**From:**  
**Sent:** 11 February 2026 21:13  
**To:** DC Admin  
**Subject:** Re: Planning notice application no 2025/93438

My house is adjacent to the Arena Young Peoples Centre where the development of a care home and day centre is being proposed.

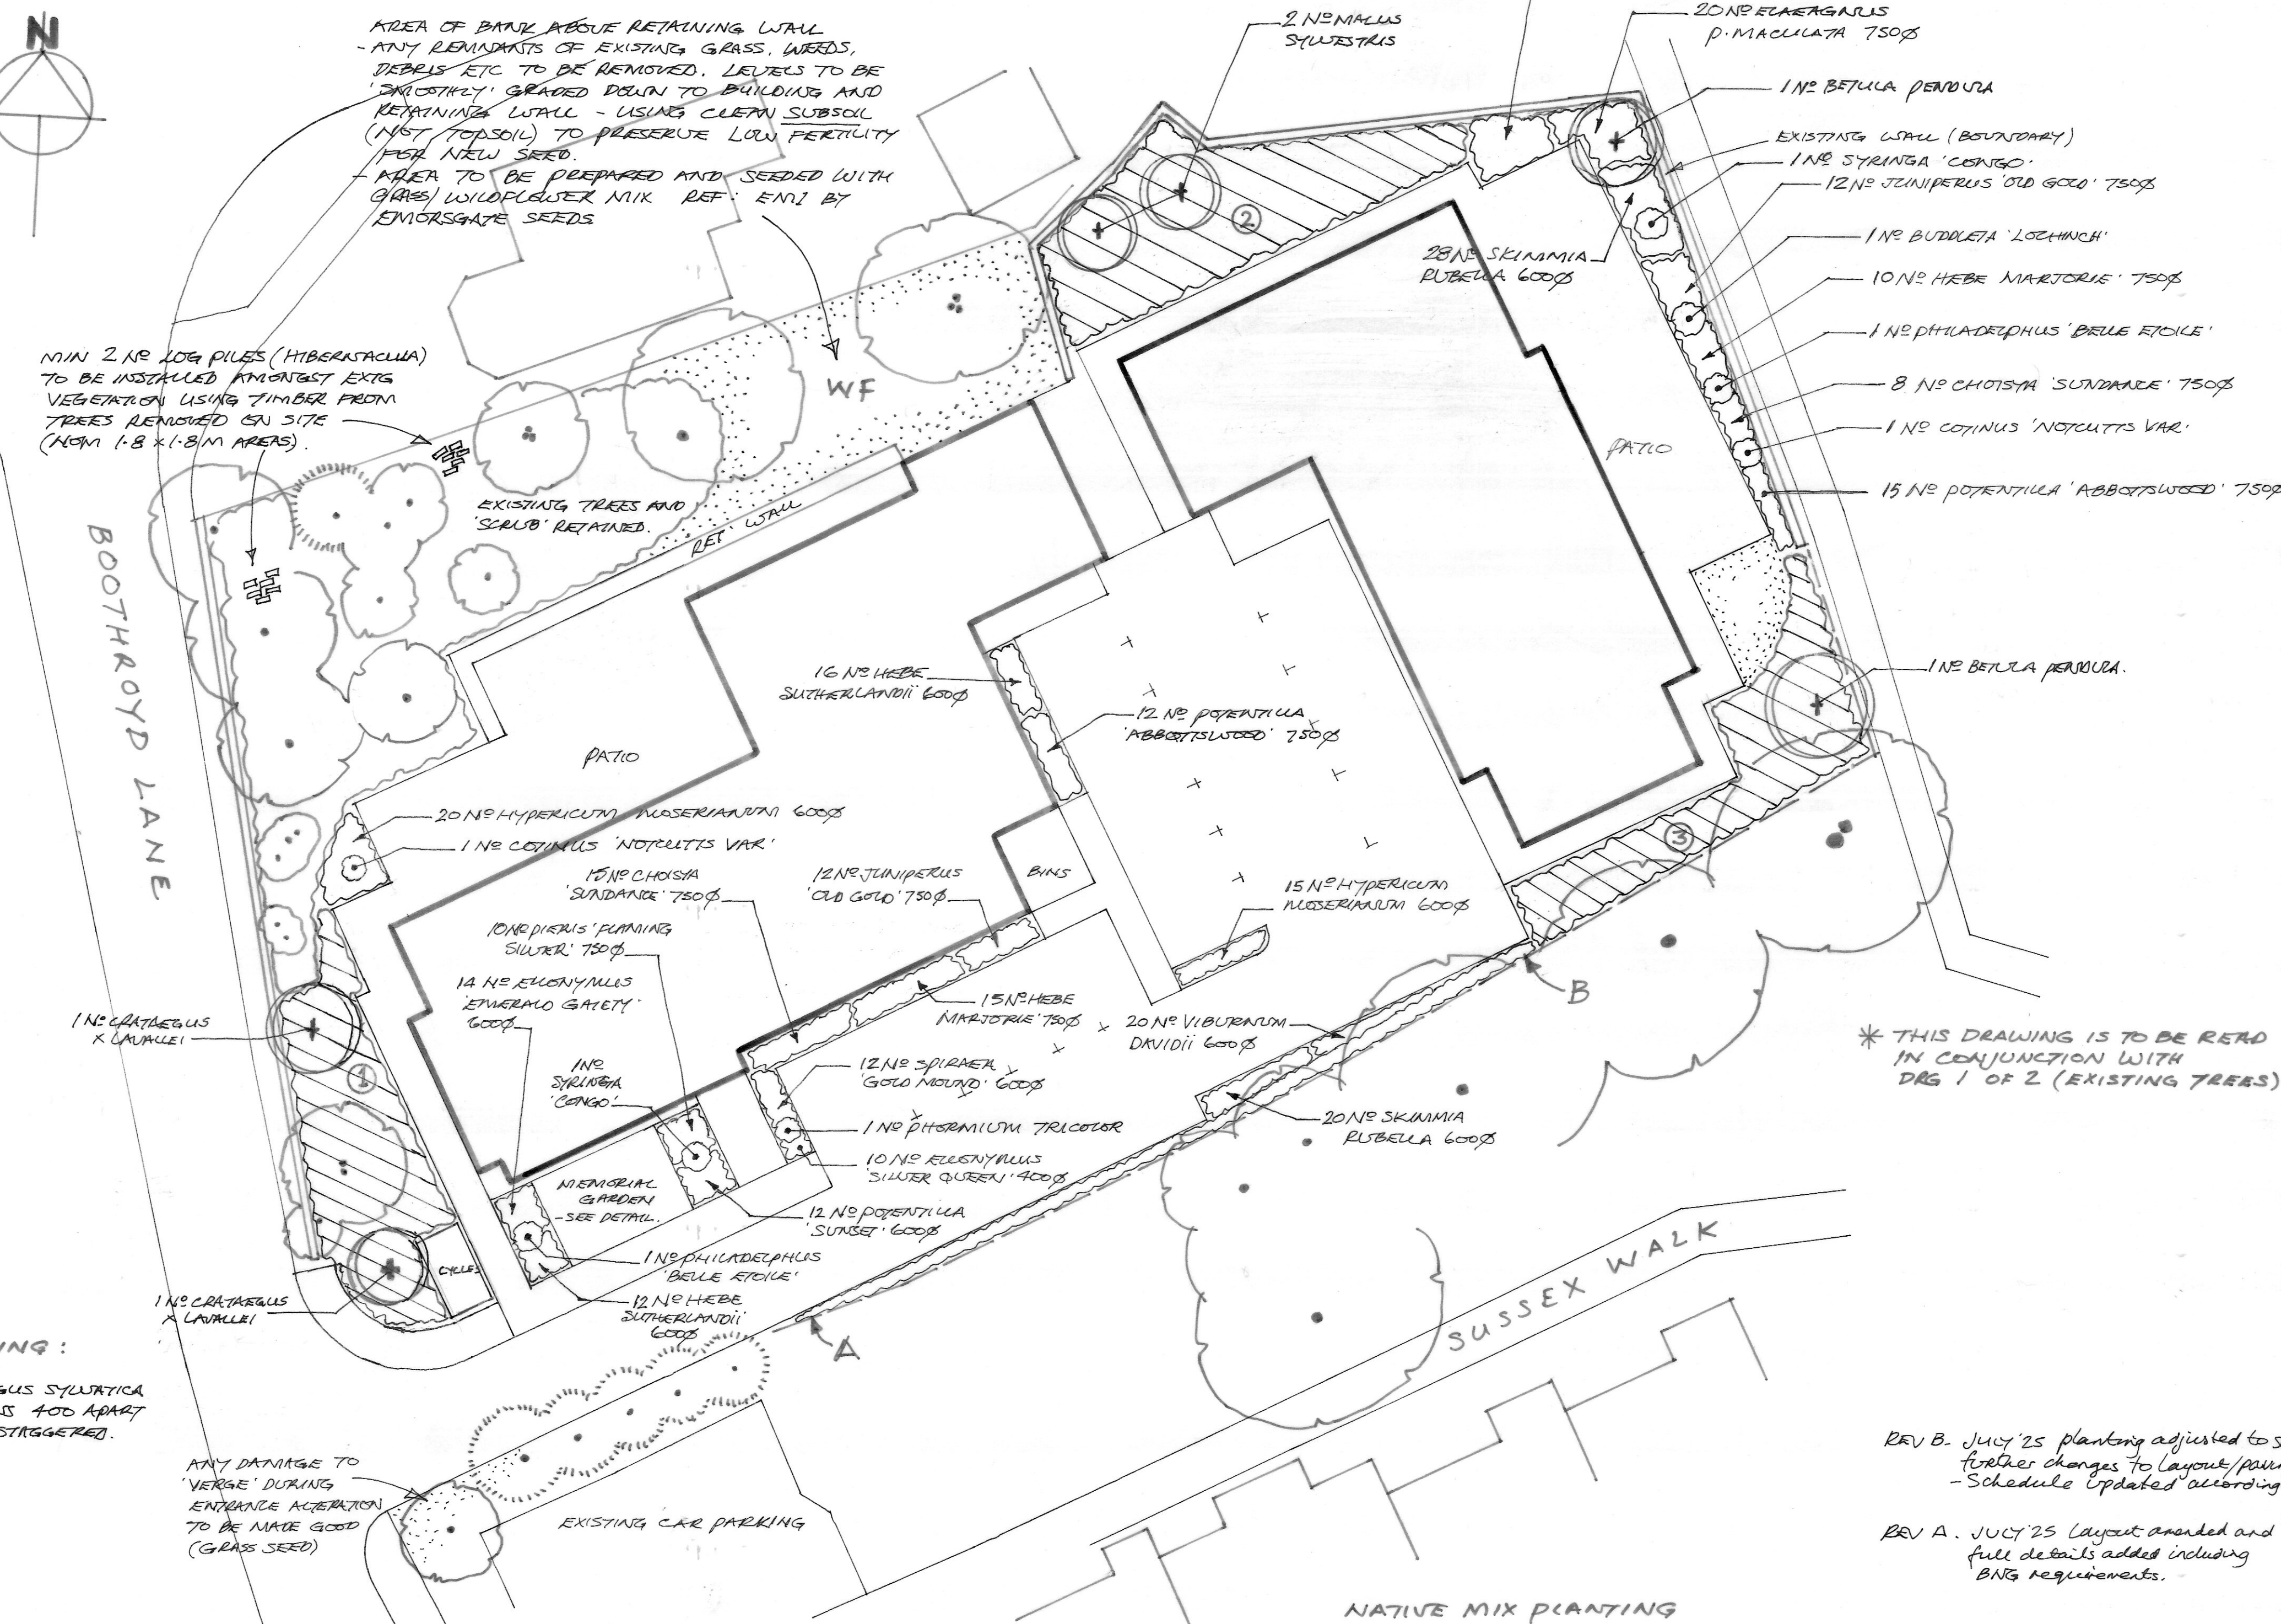
I have reviewed the plans. I note that plantation of tree's is planned adjacent to and in the near vicinity of the boundary wall of 77 Moorlands Road.

This would be potentially detrimental to my building at 77 Moorlands Road, therefore plantation adjacent to 77 Moorlands Road should be avoided to prevent any future claims.
